Shane Johnson BS, MA
Environmental Health Specialist II
Kittitas County Public Health
507 N. Nanum St. Suite 102

December 23, 2024

SP-24-00015 Schmitt

SCHMITT SHORT PLAT

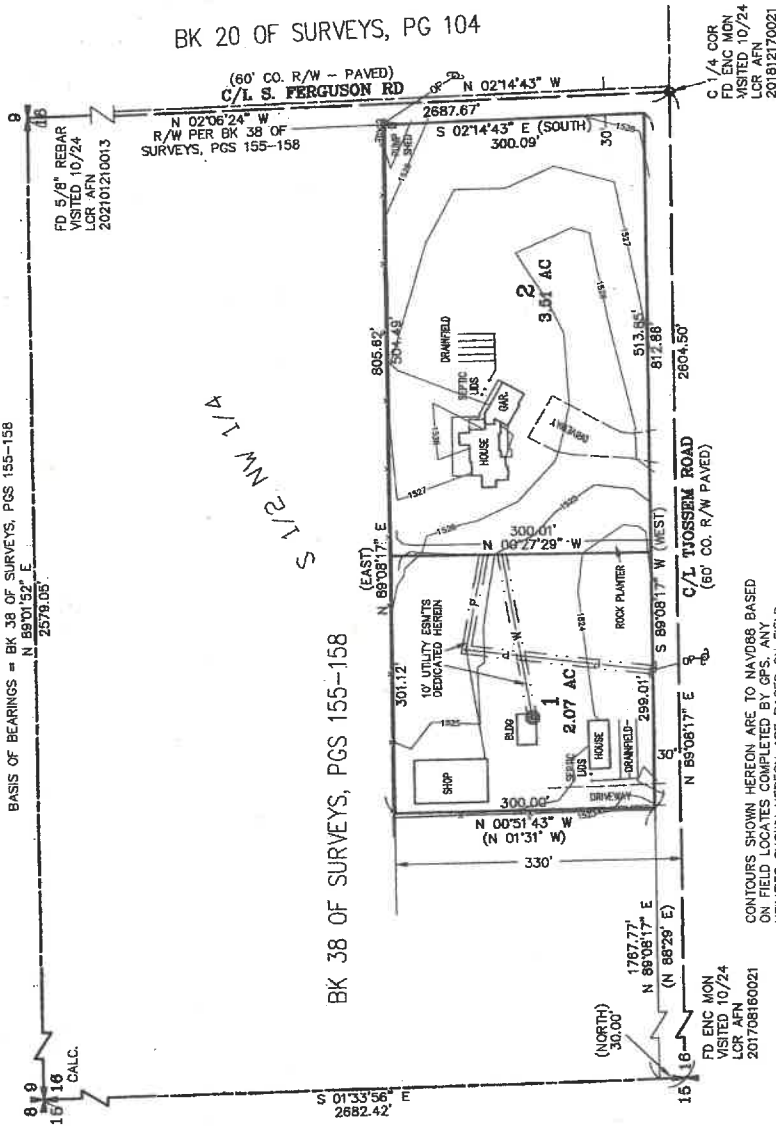
1. Between Lots 1 and 2 a written and approved shared well agreement will need to be submitted between the two lots.
